Consultation Response KC Landscape

Planning Number:	2025/90517		
Proposal:	Outline application, including the consideration of access and layout, for two commercial units (use class B2 and/or B8) and associated works		
Location:	land off, Forge Lane, Thornhill Lees, Dewsbury, WF12		
DEVELOPER/APPLICANT/AGENT:	Malcolm Sizer Planning Ltd		
Planning Officer:	Jillian Rann		
Date Responded:	19.08.2025	Responding Officer:	Landscape
Site Area (Hectares)		Responding Ref:

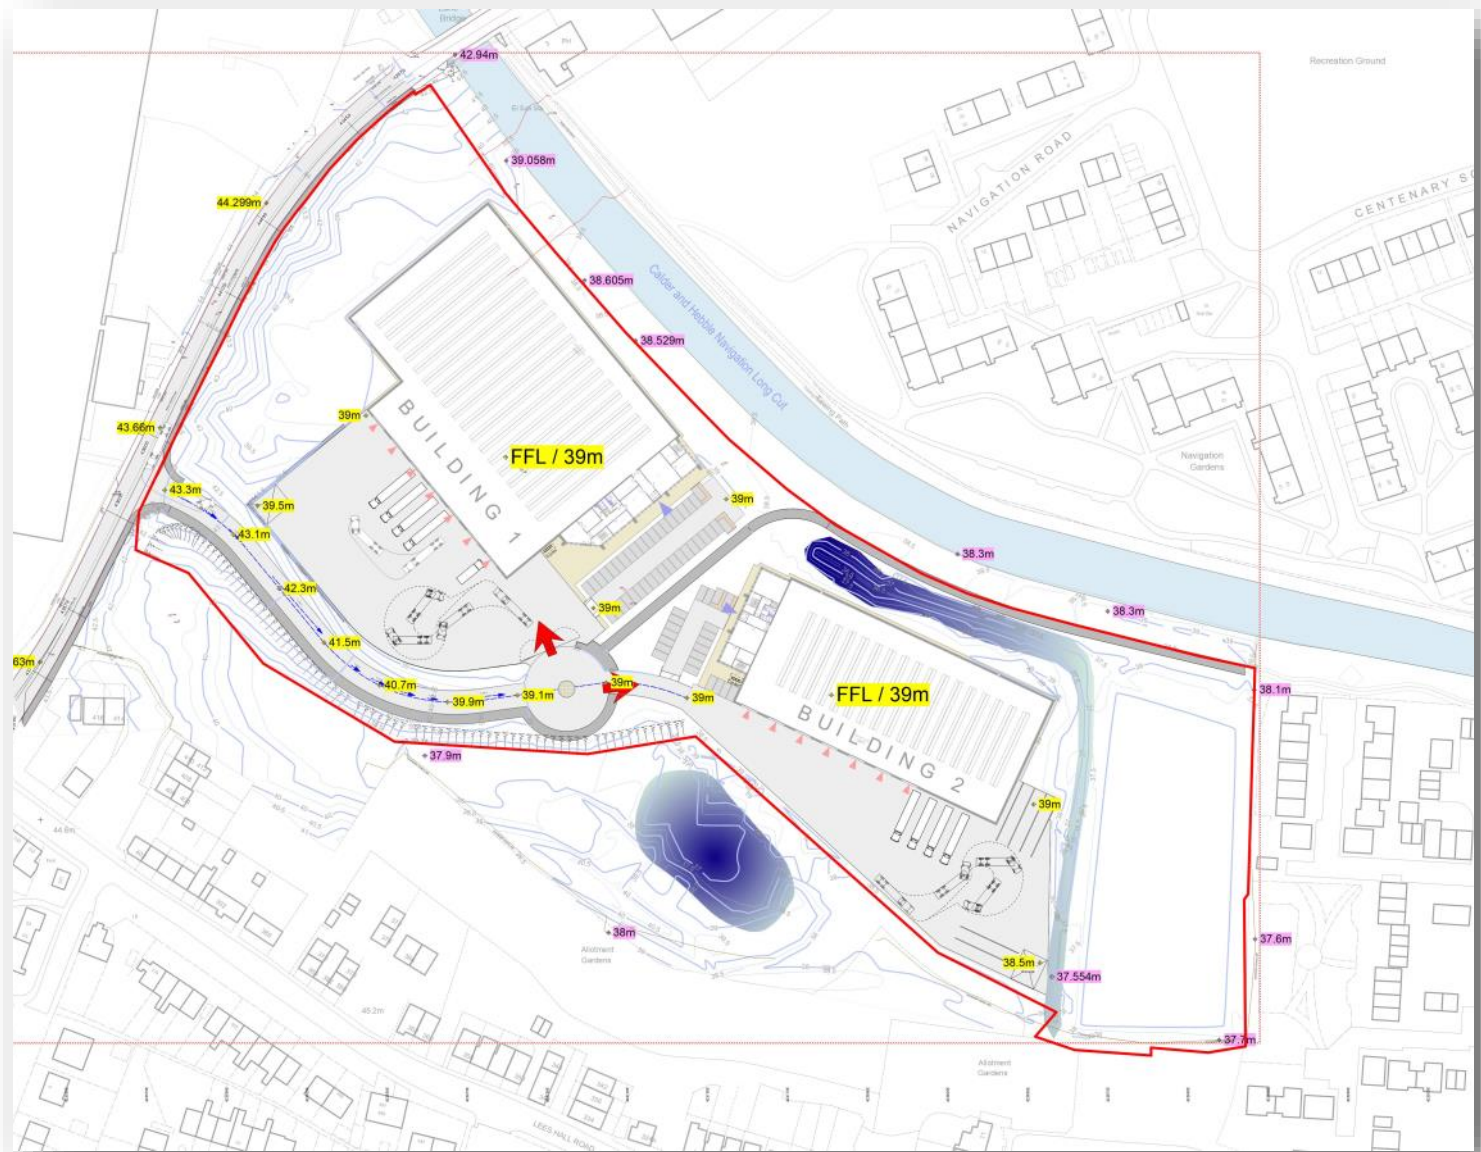
2. New developments are to retain and incorporate existing significant trees within the layout as stated within Kirklees Local Plan policy LP33. Tree planting adjacent to carriageways accords with the West Yorkshire Combined Authority's "Green Streets" principles, as well as paragraph 136 of the NPPF.
3. The plan is very indicative in landscape terms, therefore difficult to provide meaningful comments, however, some greenspace on site is shown and is welcome, however, consider access and purpose of the spaces being created.

4. Will the spaces provided be for the employees and visitors or for the wider public to access? Clarification is required and irrespective, any open space provided for use, needs to be designed to meet the needs of the widest possible range of users, be easily accessible and enjoyed by all people, regardless of visual, physical and cognitive ability, mobility, background or age.
